From: David Robinson [REDACTED]
Sent: 15 December 2014 10:31
To: Simon Davis
Subject: Re: App Ref Y/93/14/OUT - Land North of Yapton C of E Primary School

I have now had the opportunity to fully appraise the layout and I set out my thoughts on this below:

DRAWING NO YAP/DR/1

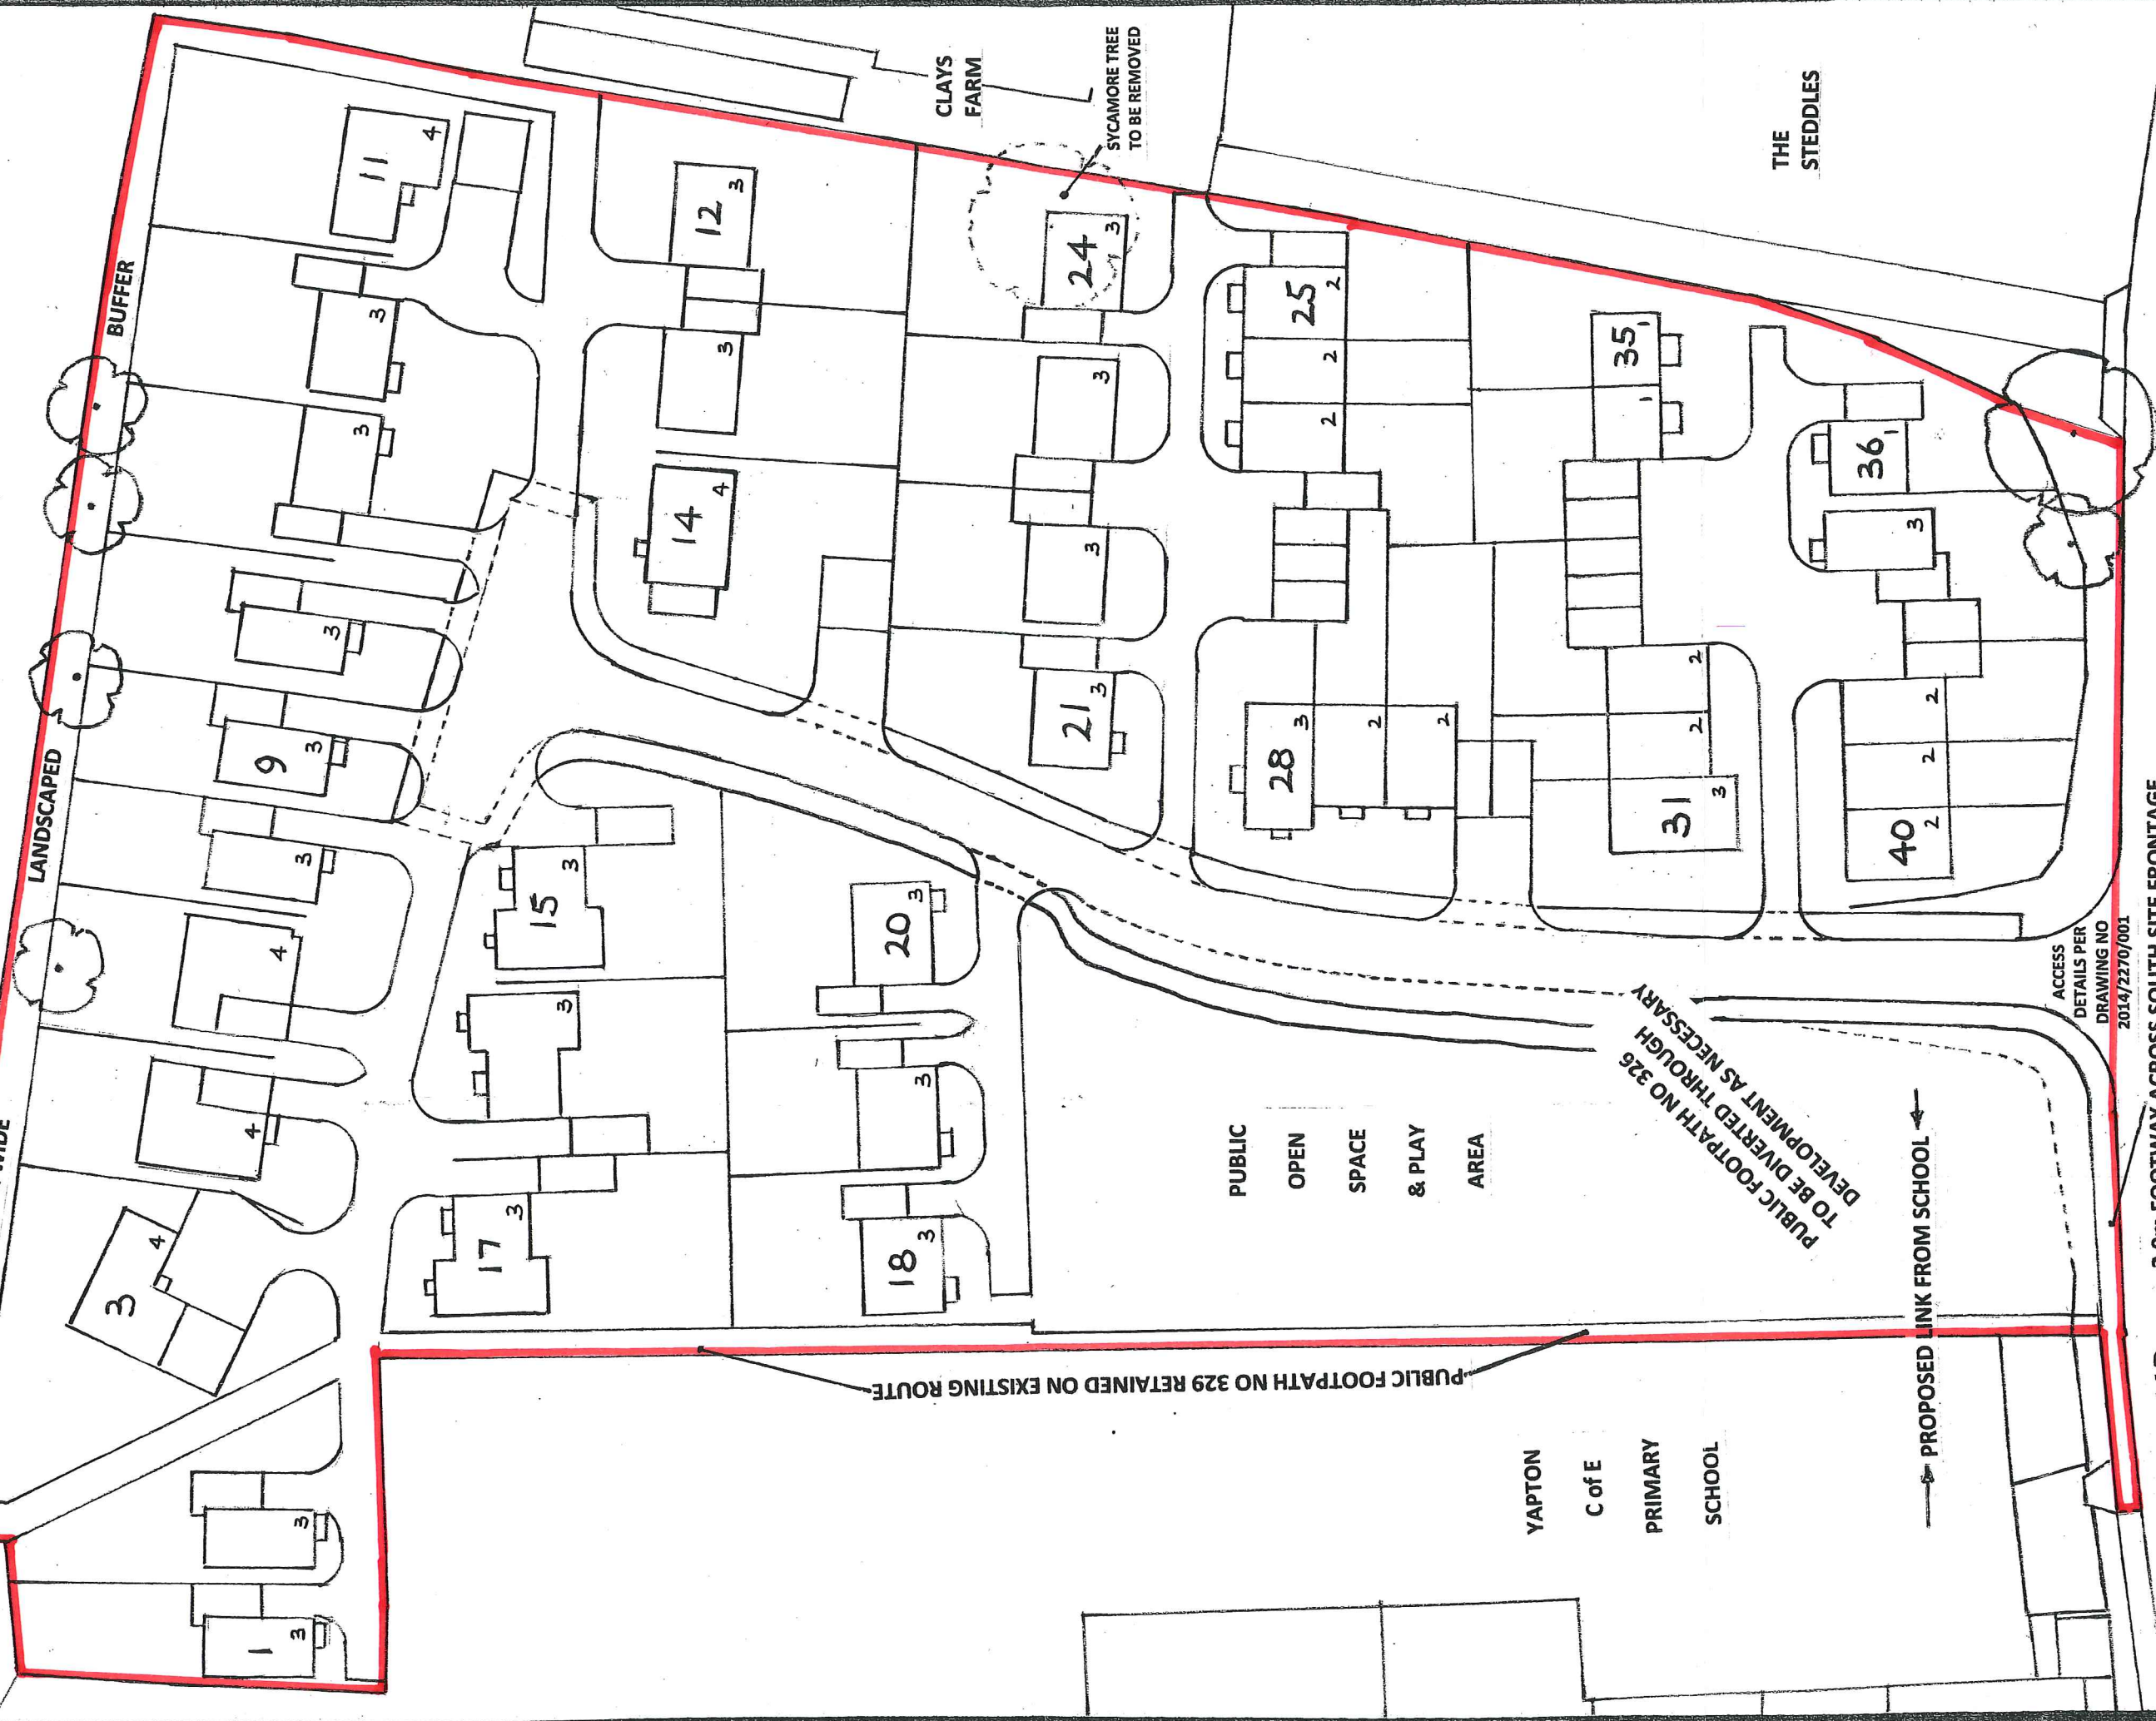
- We think that there is a lot of hardstanding shown – particularly in the cul-de-sacs.
- We are not keen on the instances of blocks of garages. Two garages together might be ok where the dwellings that they serve are adjacent (e.g. Link detached) but three or more together is not good urban design.

- I also notice that plot 11 at the western end has a double garage only around a metre from the front of the dwelling.
- We also think the layout just seems dated in its design and have concerns that the layout does not result in any real sense of place.

- We have concerns as to whether all of the plots will meet the Councils internal and external space standards policies (see policies D DM2 and D M3 of the emerging Local Plan). Although we will accept layouts where less than 100% of plots meet the standards, some of the private rear gardens in this layout (particularly in the eastern half of the site) are very small and may not be acceptable.

- We will not accept dwellings having their back gardens onto North End Road. Dwellings should front onto this road and then those to the rear should be in a back to back arrangement.

- We appreciate that there is no firm guidance yet from the School/WSCC Education but if they want a new staff parking area (or even if they do a u turn and agree to the drop off area, then you may need to include this within the site and this would then mean less space for houses.

- We have not yet had formal comments from Landscapes but I would suggest that they will agree with me in that the buffer planting along the western edge is not wide enough particularly as trees planted here will reduce light to gardens and there will be pressure to fell in the future.

- We are also unsure – are you showing a footpath along the western half of the site? It appears as though you are. I suspect that the Police will object to such a footpath.

On the above basis, we would not support the current layout and consider that you cannot achieve 40 dwellings. Although layout is to be considered at this time, we do not believe that 40 dwellings can be achieved on the site if the suggested layout is followed and we therefore request that you agree to changing the description to say "Outline Application with some matters reserved for the erection of up to 40 No. dwellings each with a garage(s) and/or parking space(s), together with the means of access off North End Road".
